Your Ref: OWPC18588
Our Ref: CM/10/18/OUT 03-04-2018
Please ask for:
Mr J Baeza

Application for Outline planning permission with some matters reserved for redevelopment of the site with 1 No. 4-bed detached bungalow, 1 No. 3-bed detached chalet bungalows & 2 No. 3-bed semi-detached bungalows & associated works.

Mistletoe Farm Horsemere Green Lane Climping

*indicative front elevations*

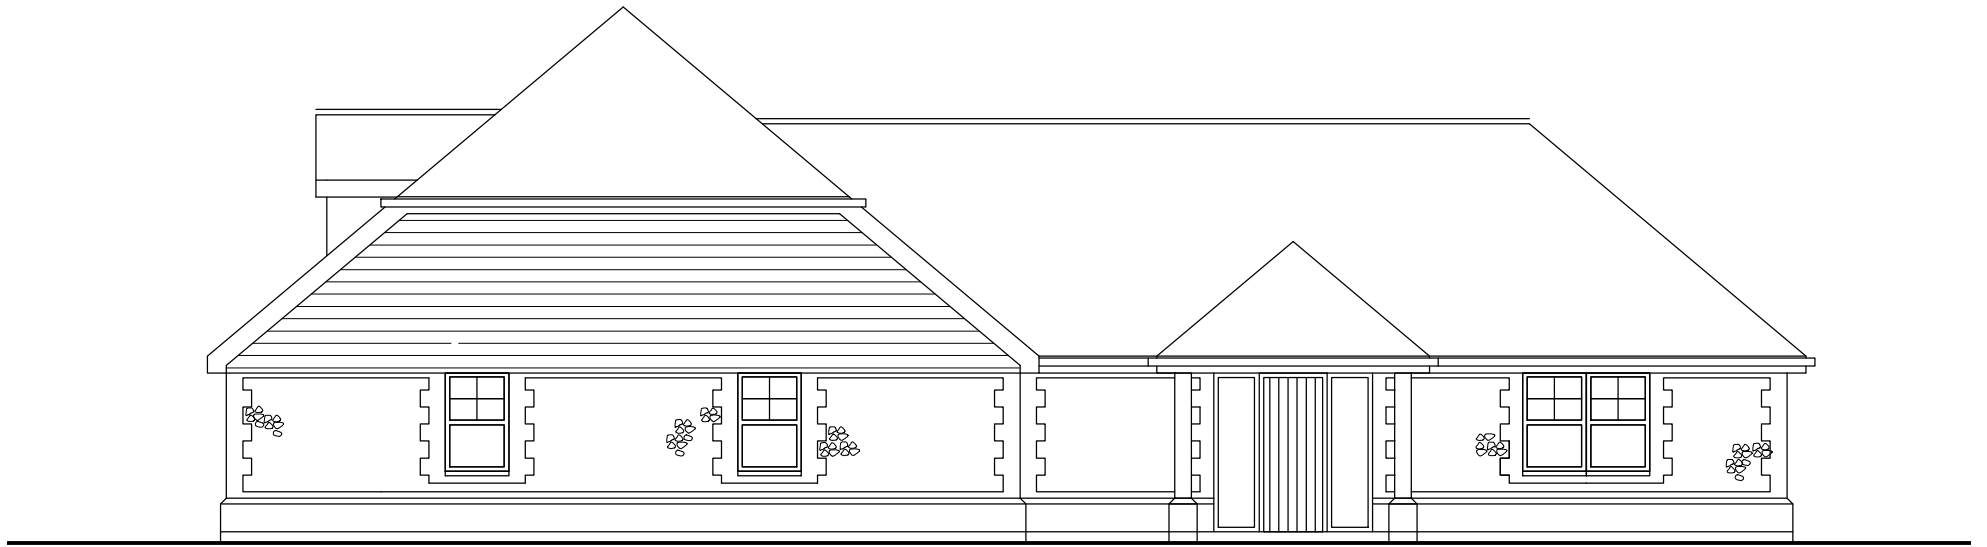
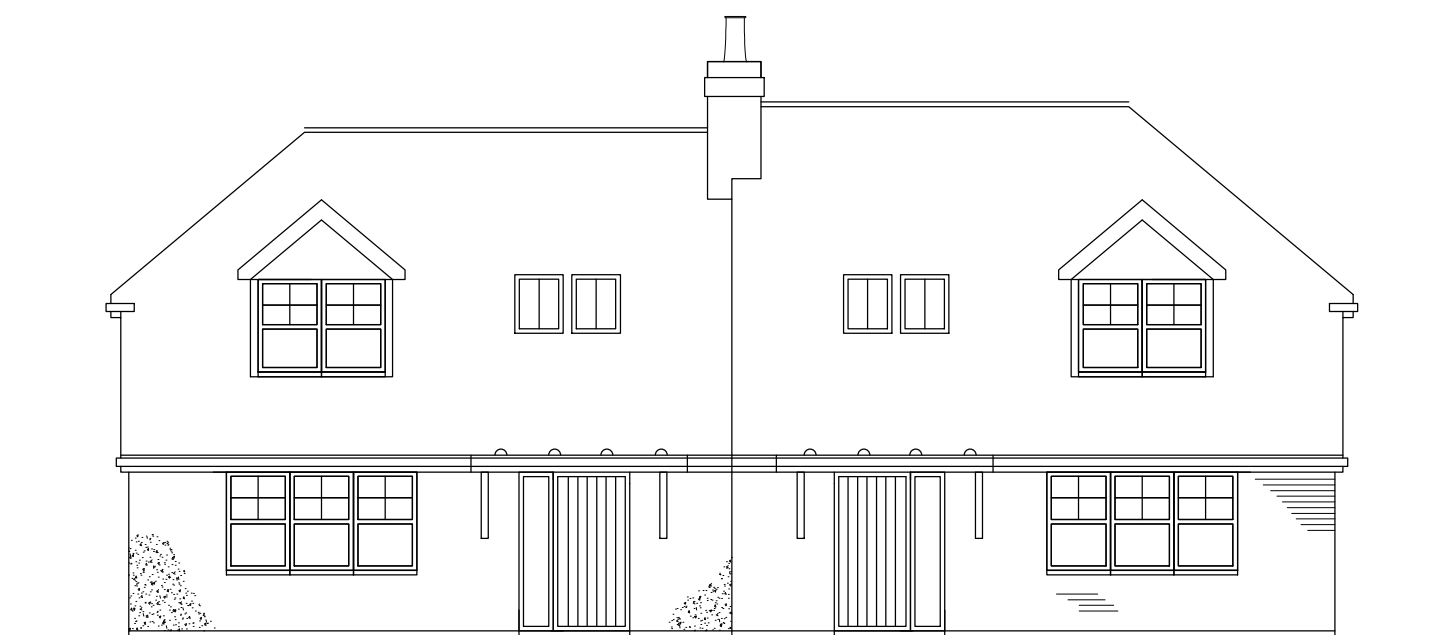
The site is too small for the number of bungalows suggested. In addition they should be true bungalows such as those in nearby Wooldridge Walk, and not have rooms in the roof.

This will protect the privacy of adjacent properties.

title  
**VISIBILITY SPLAYS AT ACCESS**

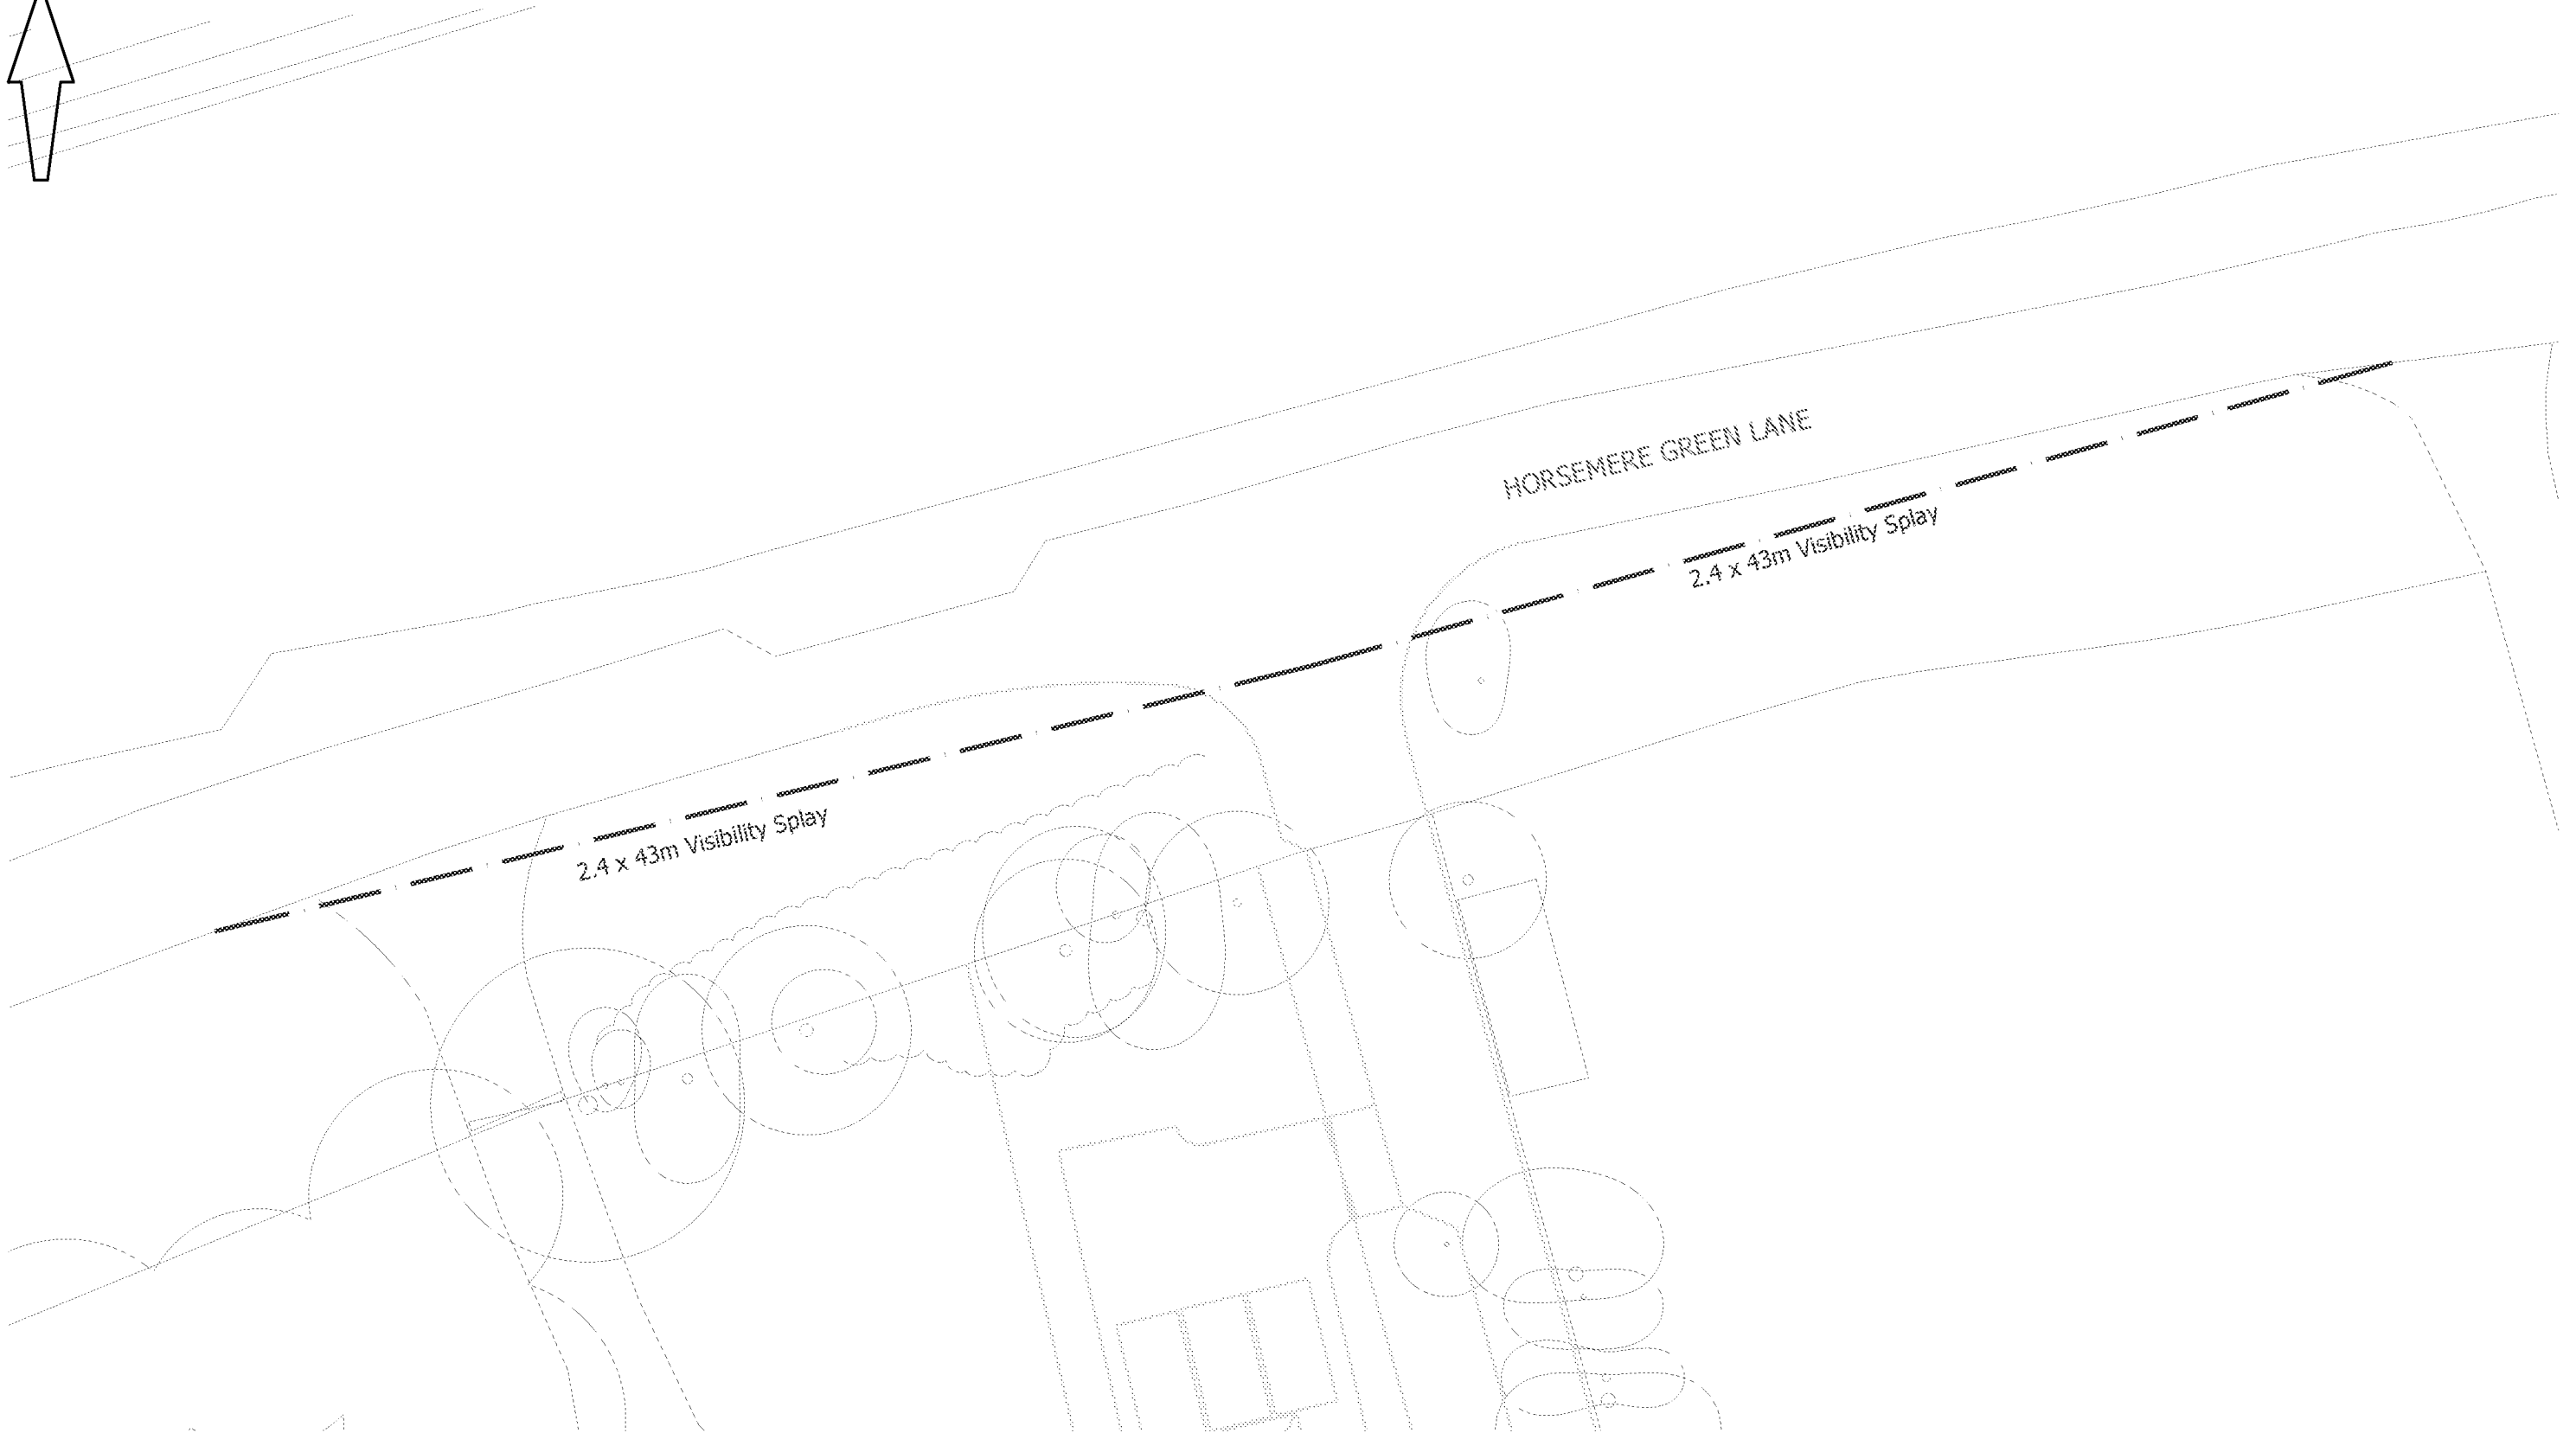
The affect on traffic in Horsemere Green Lane needs addressing as entering and exiting the site needs to be safe for road users and pedestrians alike. As we know this road is still being used as a rat run despite traffic calming. The traffic island recently installed will have to be moved.
